**RE: 6/2015/2459/NMA – Non-material amendment following approval of planning permission: 6/2015/2459/HOUSE – ‘Erection of single storey front, side and rear extension involving the demolition of the existing garage.’**

Thank you for your recent application seeking permission for a non-material amendment to planning permission: 6/2015/2459/HOUSE - *“Erection of single storey front, side and rear extension involving the demolition of the existing garage.”*

REAR ELEVATION 1:100

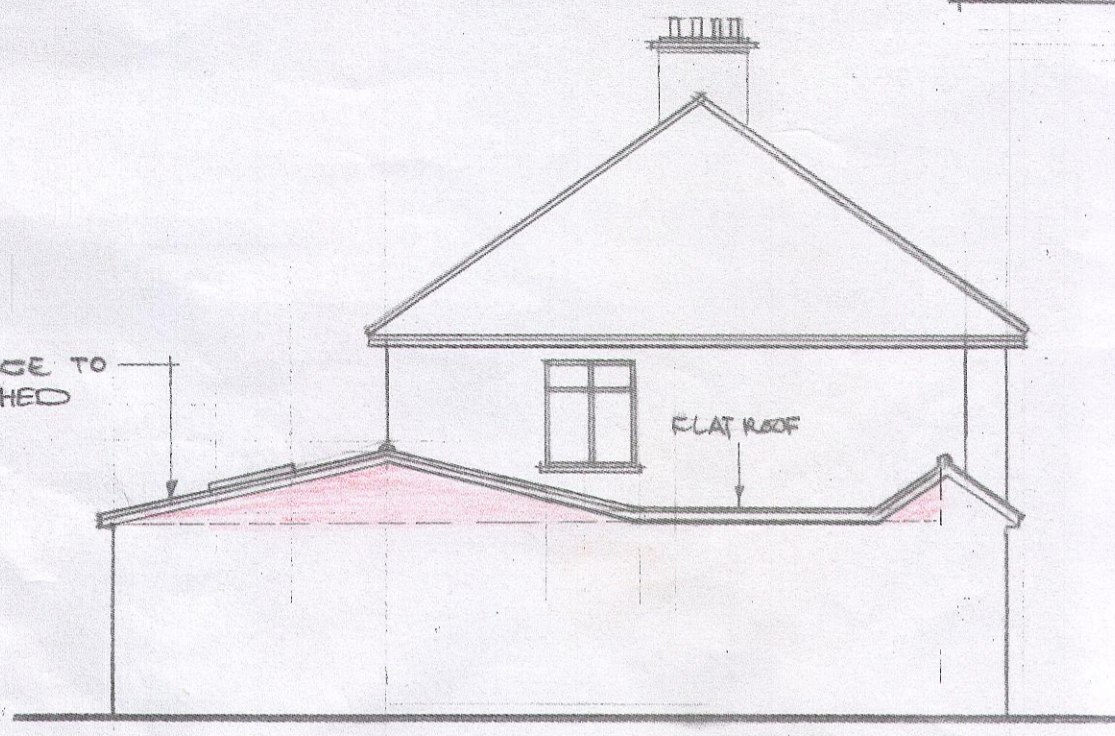
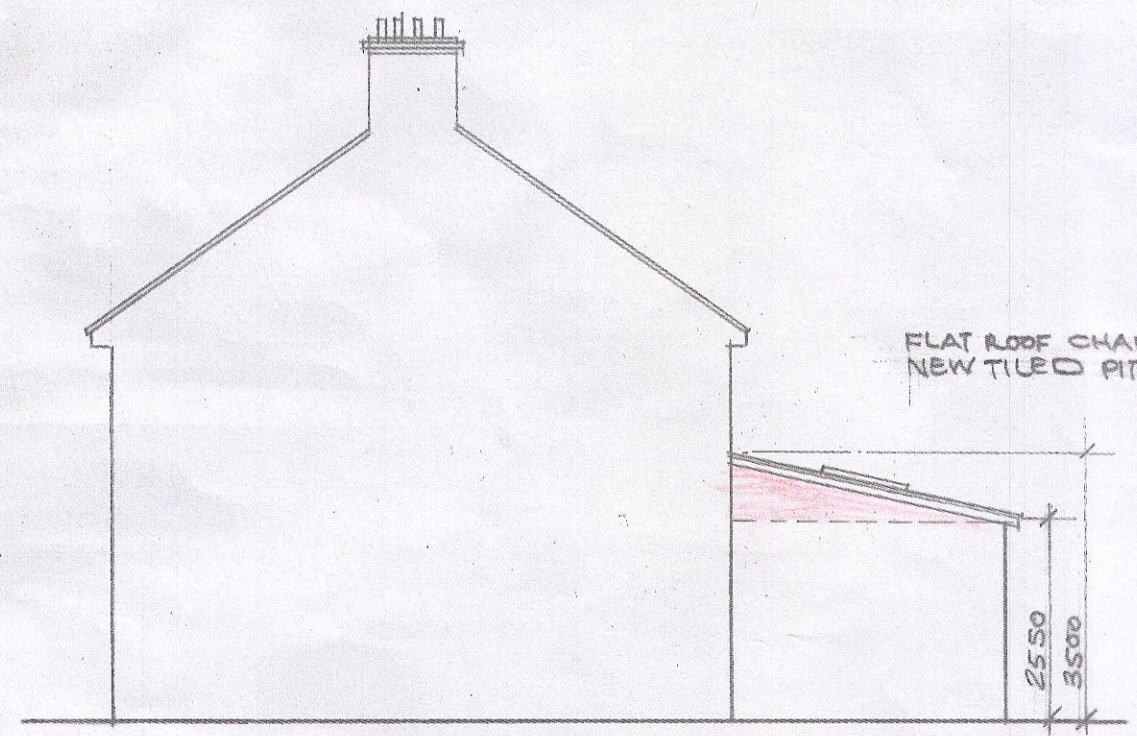
The proposal results in changes to the roof details and an increase in the height of the side and rear elements of the planning permission as originally granted. These changes are not representative of a non-material amendment. As a result, I confirm that your request for a non-material amendment has been refused.
